Our ref: 15.1.2/5/5/1
Your ref: 17/00185/F

13th April 2017

Re: Application No: 17/00185/F
Applicant: Bicester Hotel Golf and Spa Ltd
**Proposal: Erection of extension to front of existing activity hall,
 formation of outdoor swimming lake and creation of earth
 bund.**
**Location: Part Land South West Of Bicester Golf And Country Club
 Adjacent To M40 And Akeman Street Chesterton.**

Drawing Number:
 SK.16-652-103B

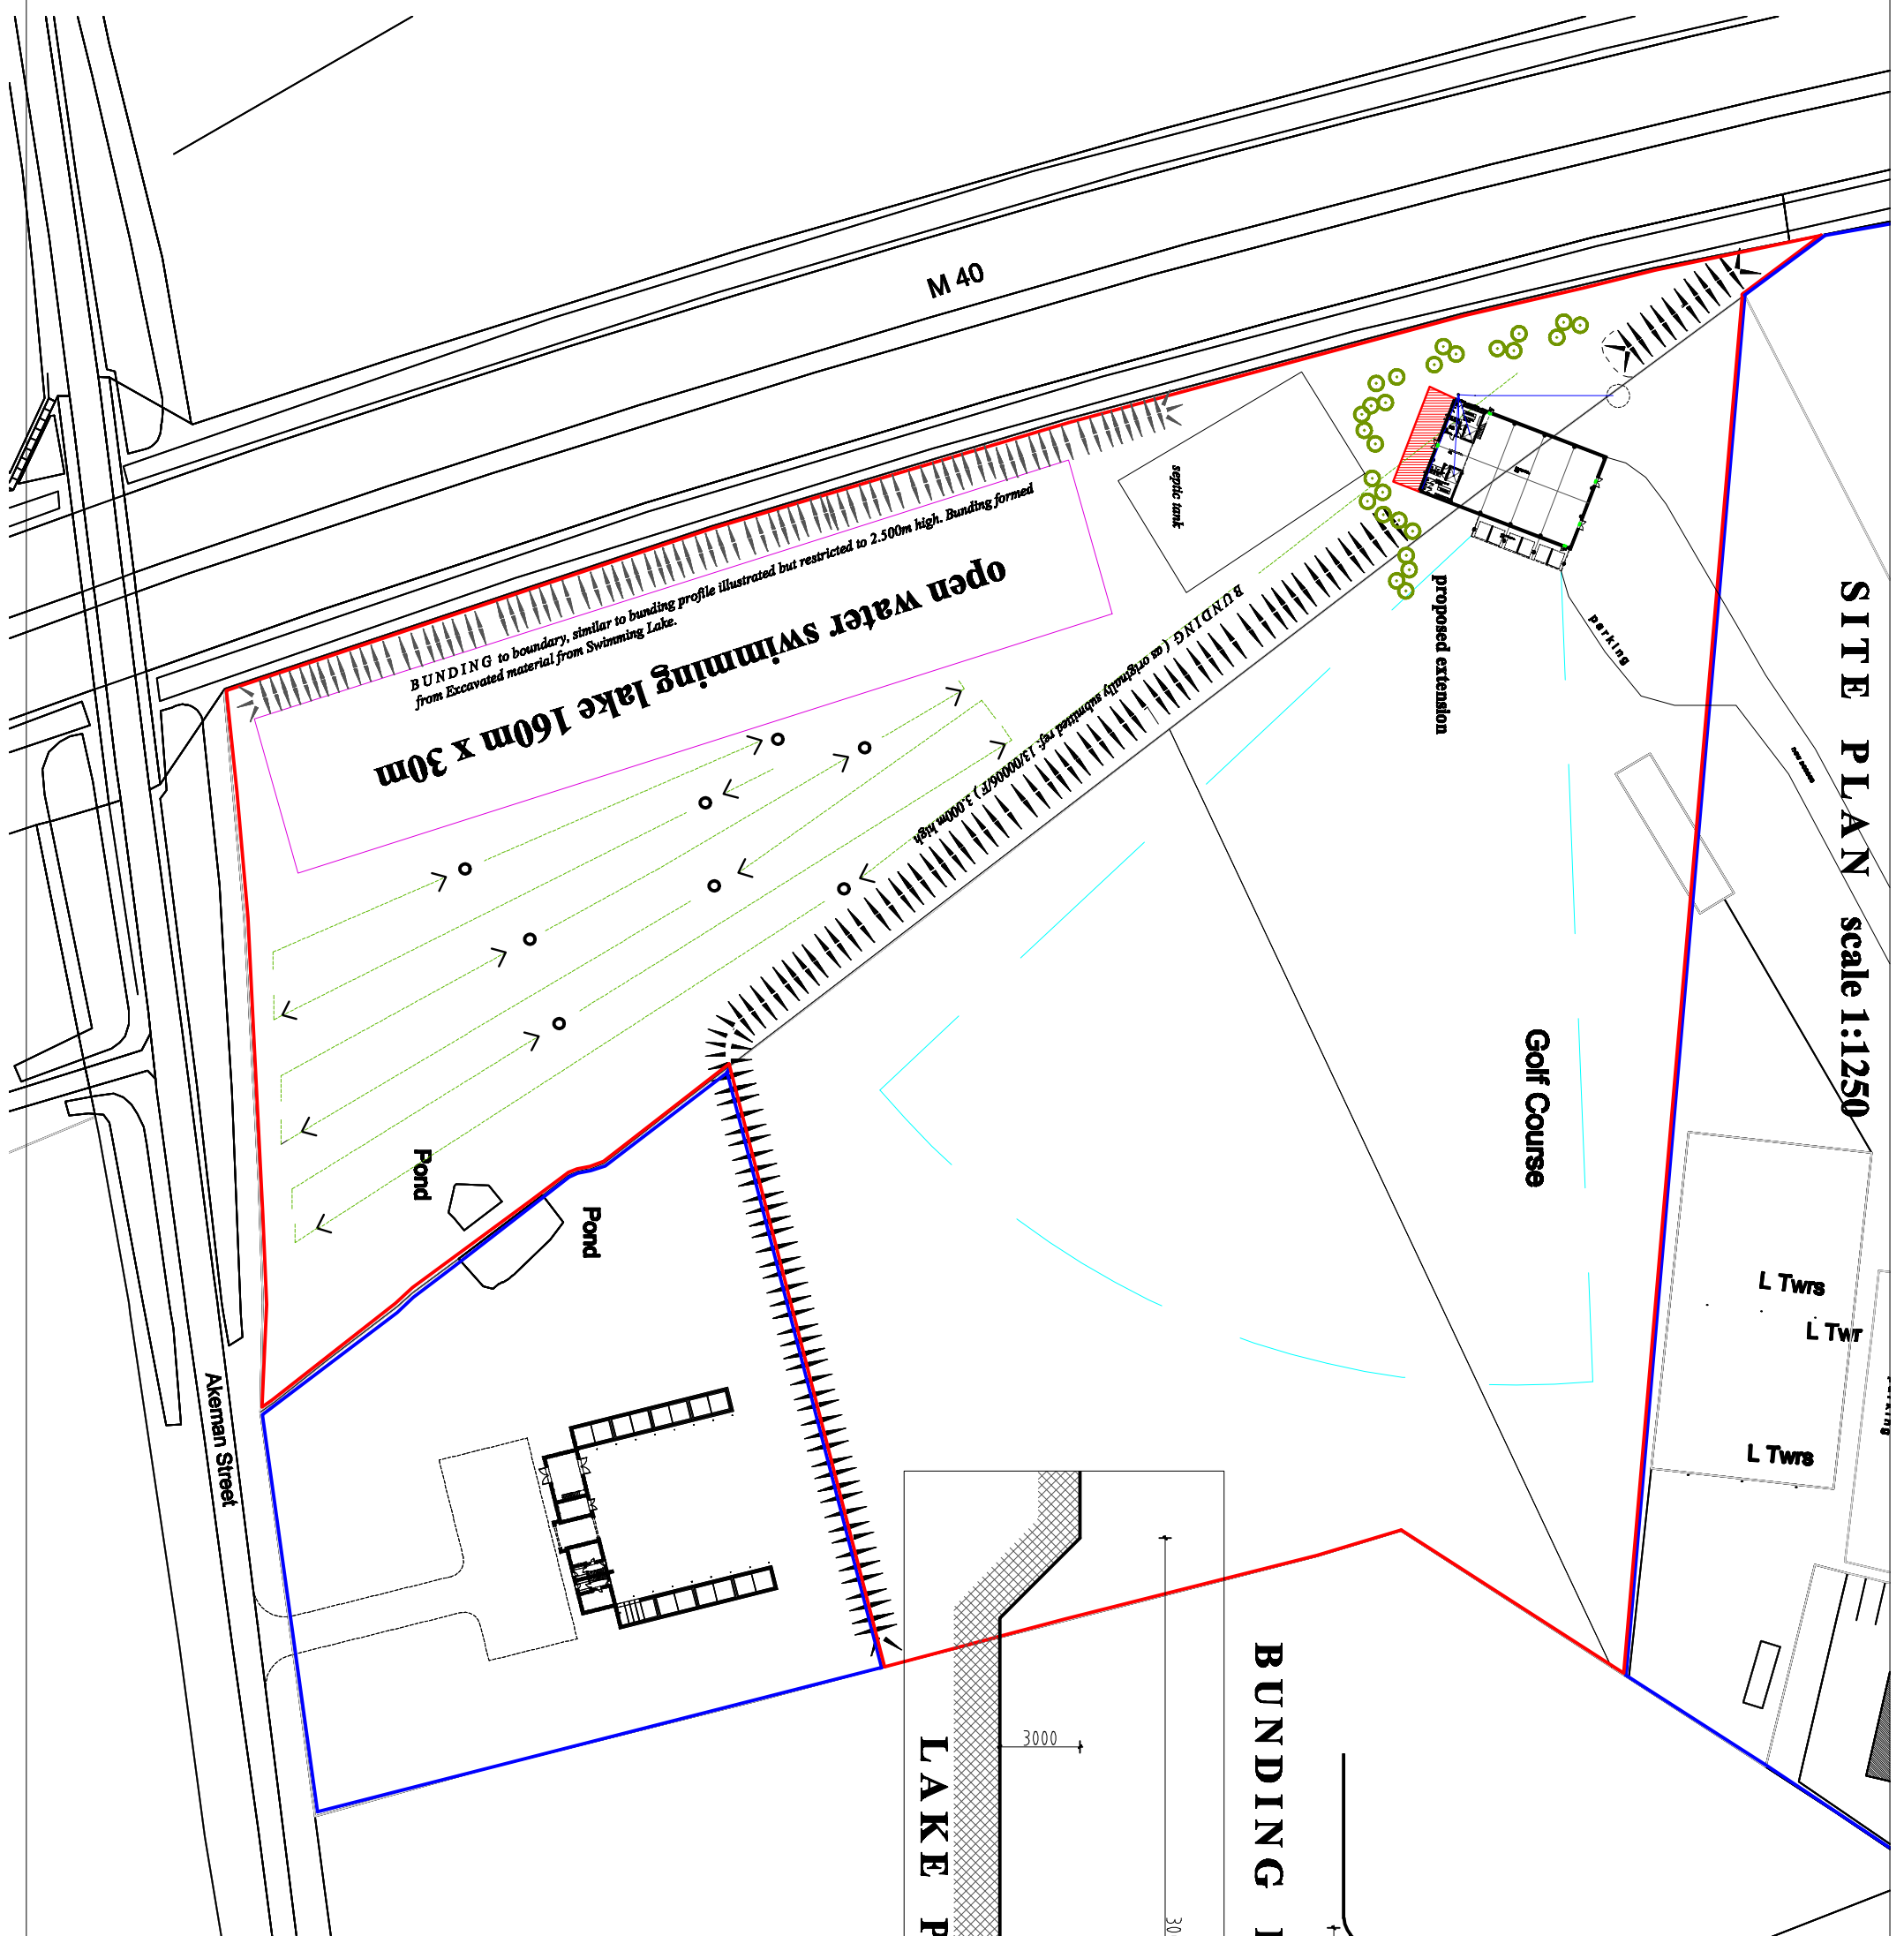
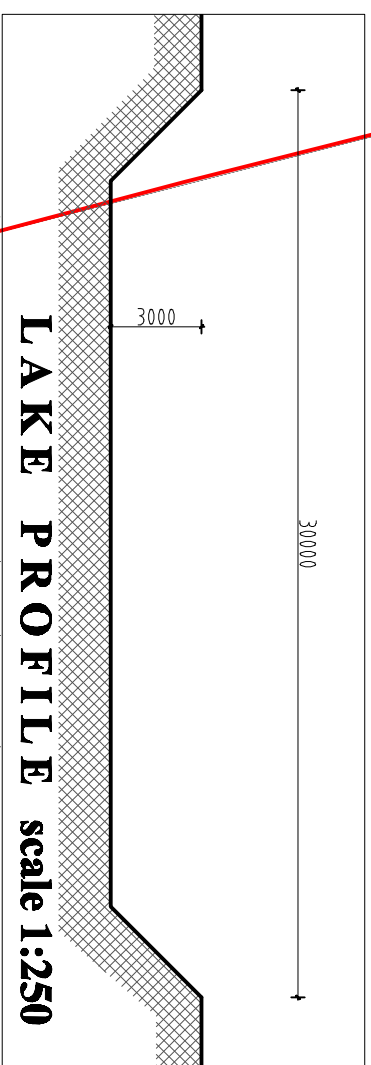
The County Council has previously responded to this consultation in an email dated 15.02.17. Although the County Council advises that the application as submitted does not have any waste planning implications for Oxfordshire, it is requested that the following condition be placed on the permission, should the application be granted:

- No material shall be imported from outside the application site for the creation of the earth bund.

This is to ensure that the creation of the bund remains an engineering operation within the site and does not involve the importation of waste.
